Application No: FG/155/25/PL  
Site Address: Land between 11A The Grove and 30 Brook Lane Ferring BN12 5HZ  
Description of works: Erection of 1 No 1-bedroom self build house with associated parking & private outdoor amenity space. This application is in CIL Zone 4 and is CIL Liable as a new dwelling.

Thank you for your internet representation made on 20th January 2026 which has been recorded as an objection with the comments as follows:

OWPC80992

A :: 2.4 x 4.8 Car Parking
01 scale: 1:200

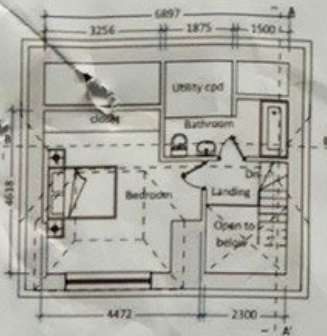
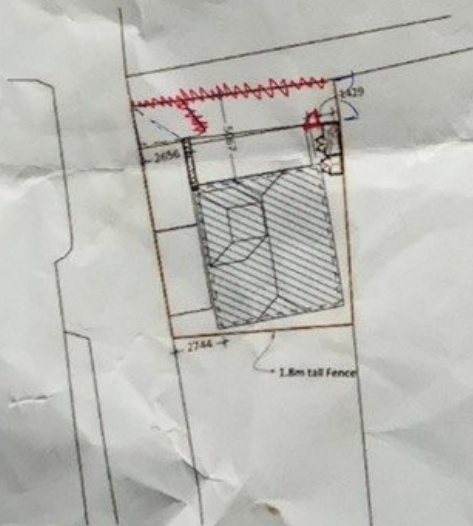
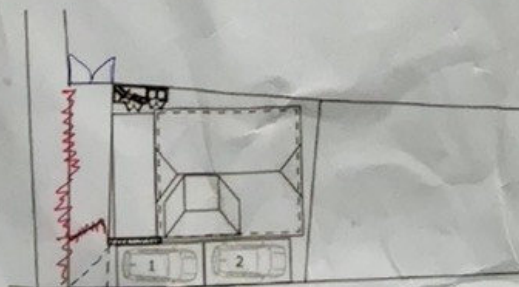
Due to the limited size of the plot, the proposed parking spaces do not meet the minimum requirements as set out in the current Manual for Streets, as confirmed by the WSCC - Highways Authority. The proposed spaces are likely to prove insufficient for vehicles to manoeuvre without difficulty. The resulting negative amenity impacts of the proposed smaller, non-compliant spaces potentially adding to on-street parking in this narrow private street with no street lighting or pedestrian footway.

The proposal presents an overshadowing impact on the neighbouring property's rear garden and outlook as it is sited so close to the eastern boundary. Sinking the dwelling and garden patio into the ground is not an innovative solution to the massing of the property but a desperate attempt to fit a dwelling onto an unsuitably small and irregular plot. There is insufficient evaluation of the impact of reducing the ground level in terms of flood risk or undermining and destabilising the adjacent access drive on the northern boundary or how these issues will be addressed.

The proposal is contrived in design and, in the limited and awkwardly shaped site area available, would still result in an unduly cramped and unneighbourly form of development. This would not only be detrimental to the residential amenities of existing and future occupiers, it would also be detrimental to the residential amenities of adjacent properties to the east and south and incongruous and detrimental to the ambience of
